Subject: Paint Brush Hills Filings No. 14 Rezone (P-18-005)

The Planning Division of the Community Services Department has reviewed the rezoning application for Paint Brush Hills Filing No. 14, and has the following comments of behalf of El Paso County Parks.

PAINT BRUSH HILLS FILING 14  
CONCEPT PLAN

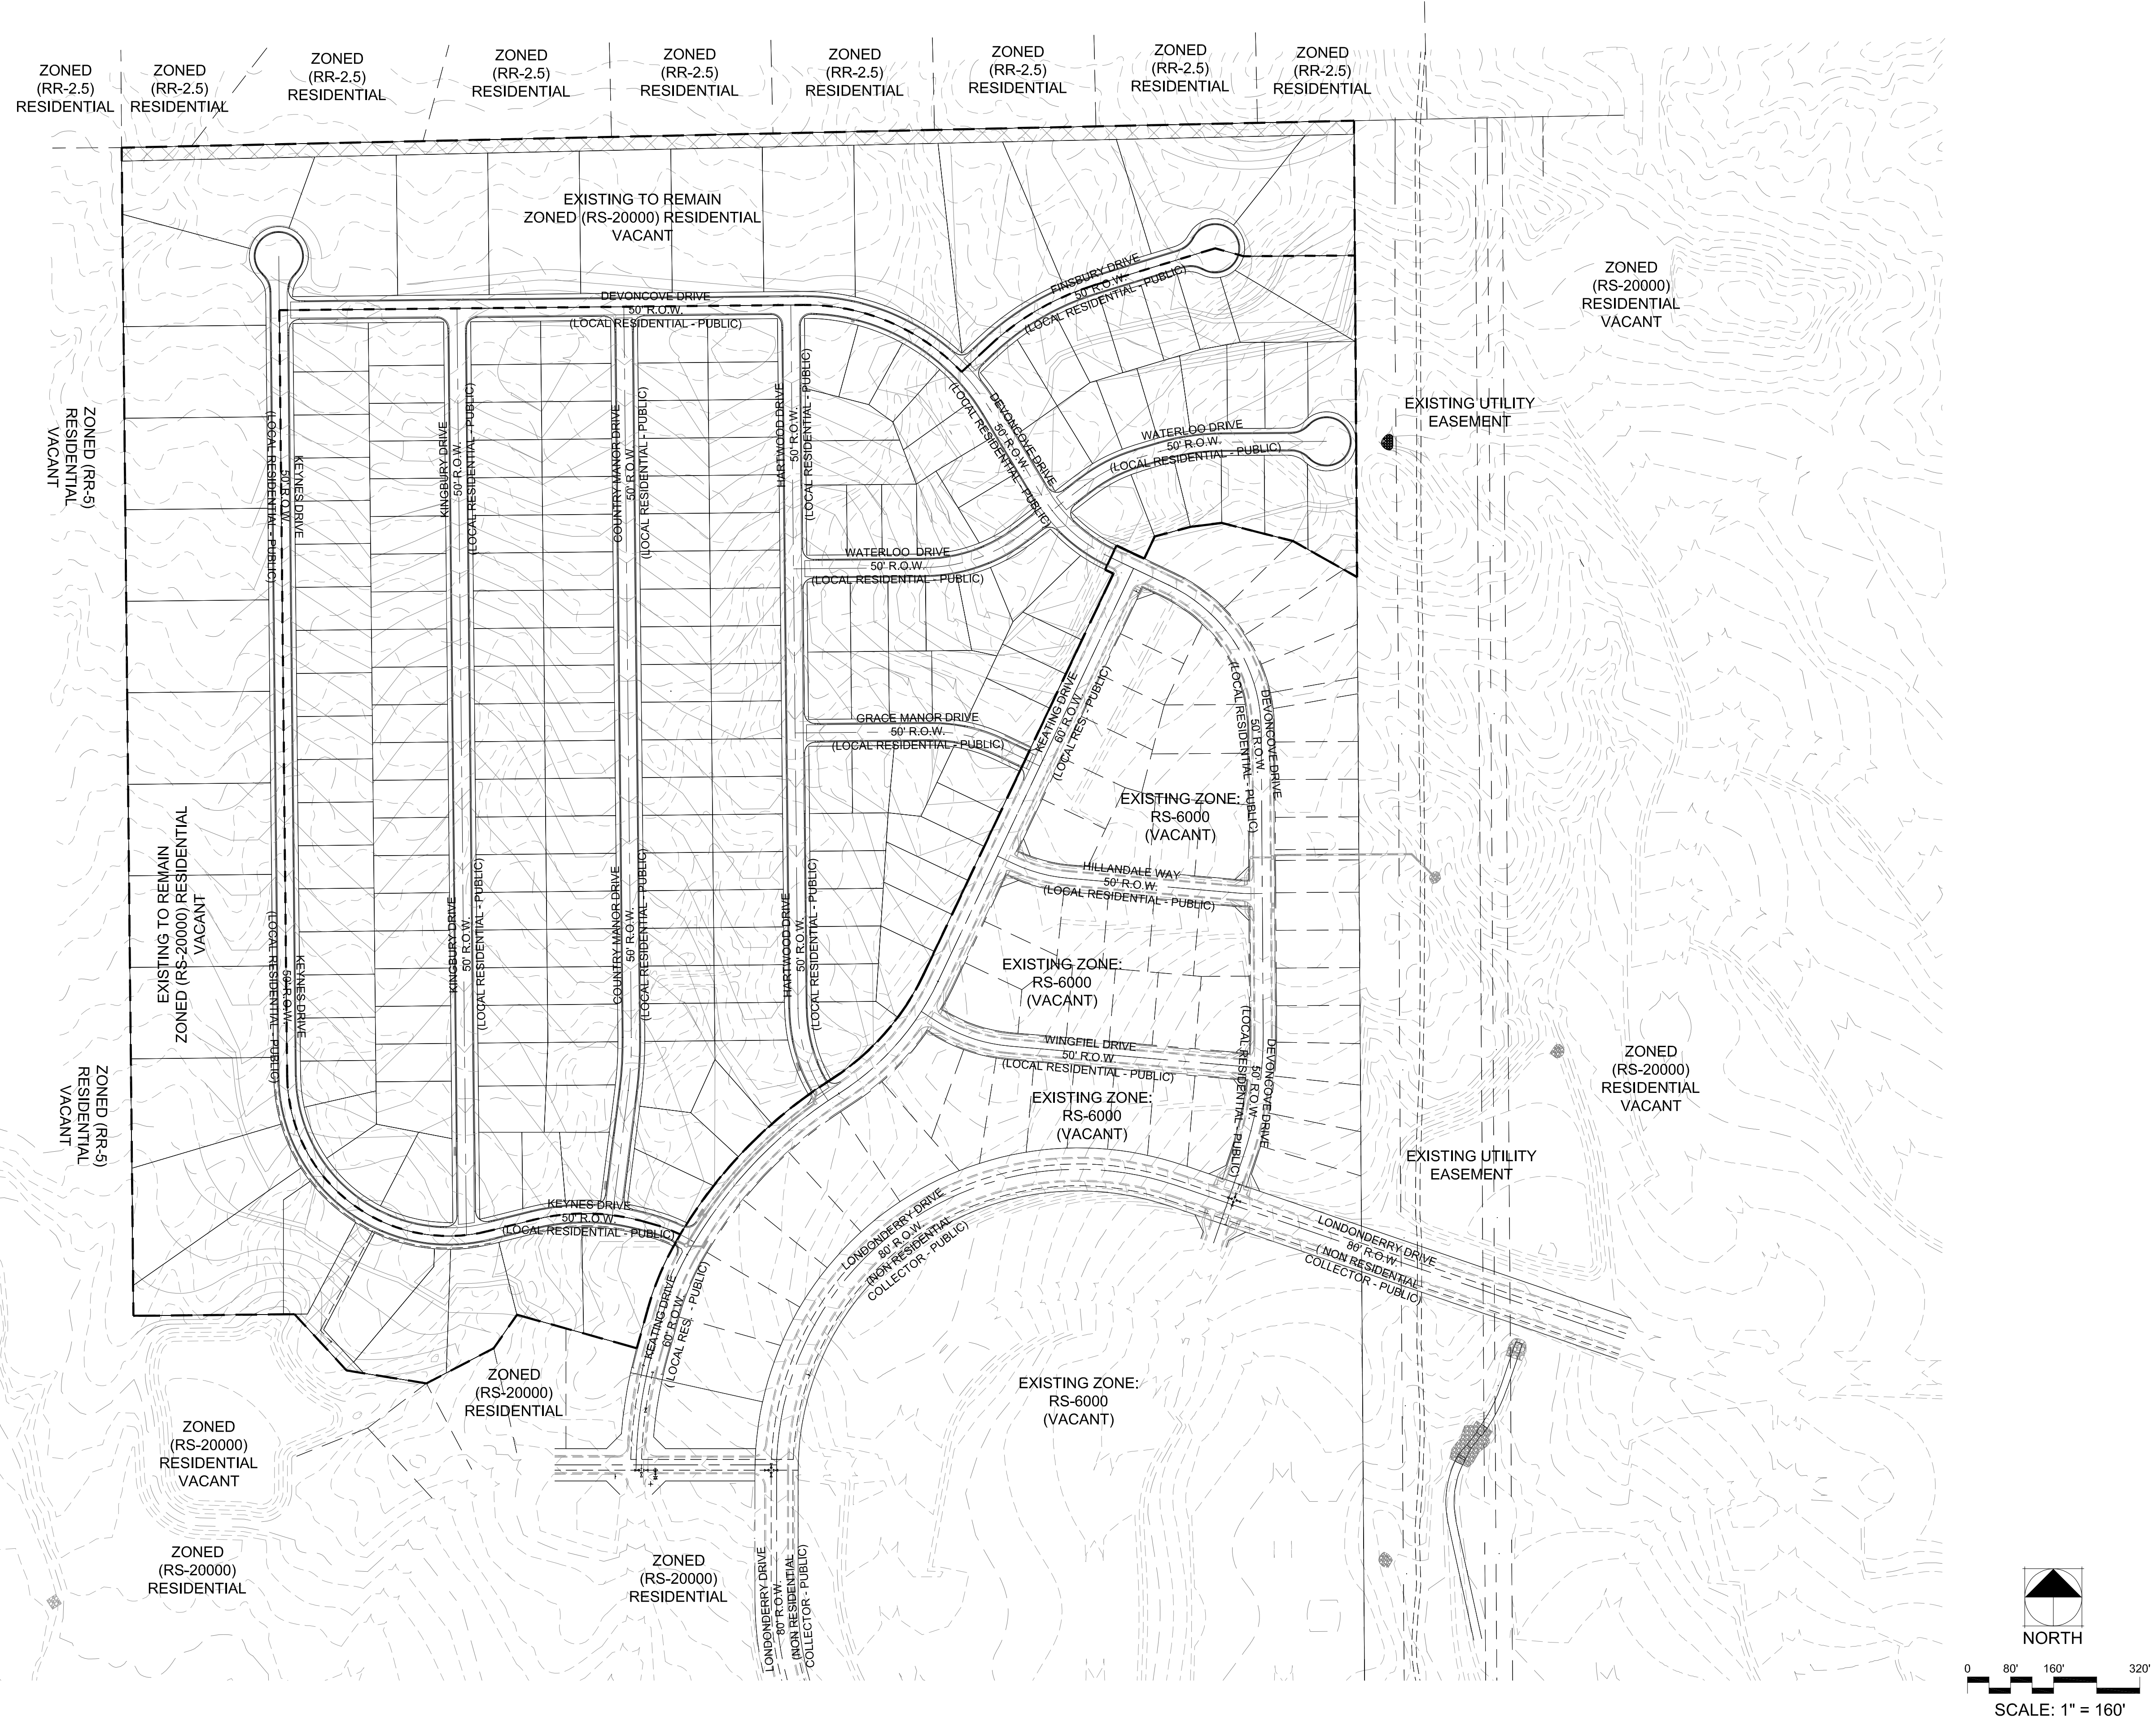
While the rezone area does not impact the trail corridors, the Paint Brush Hills Filing No. 13E Final Plat, which includes Tract E and therefore the entirety of Filing No. 14, shows a 275' section of a 25' regional trail easement along the northern boundary of the property, which will allow for the construction, maintenance, and public access of the Arroyo Lane Regional Trail. This trail easement, however, does not extend to the west into Tract E (Filing No. 14) or east into Tract D and F (well site). Moreover, Tract E does not show a trail easement for the northern extension of the Woodmen Hills Secondary Regional Trail. While this tract is designated for future development, staff recommends the trail easement be shown on all forthcoming preliminary plans and final plats.
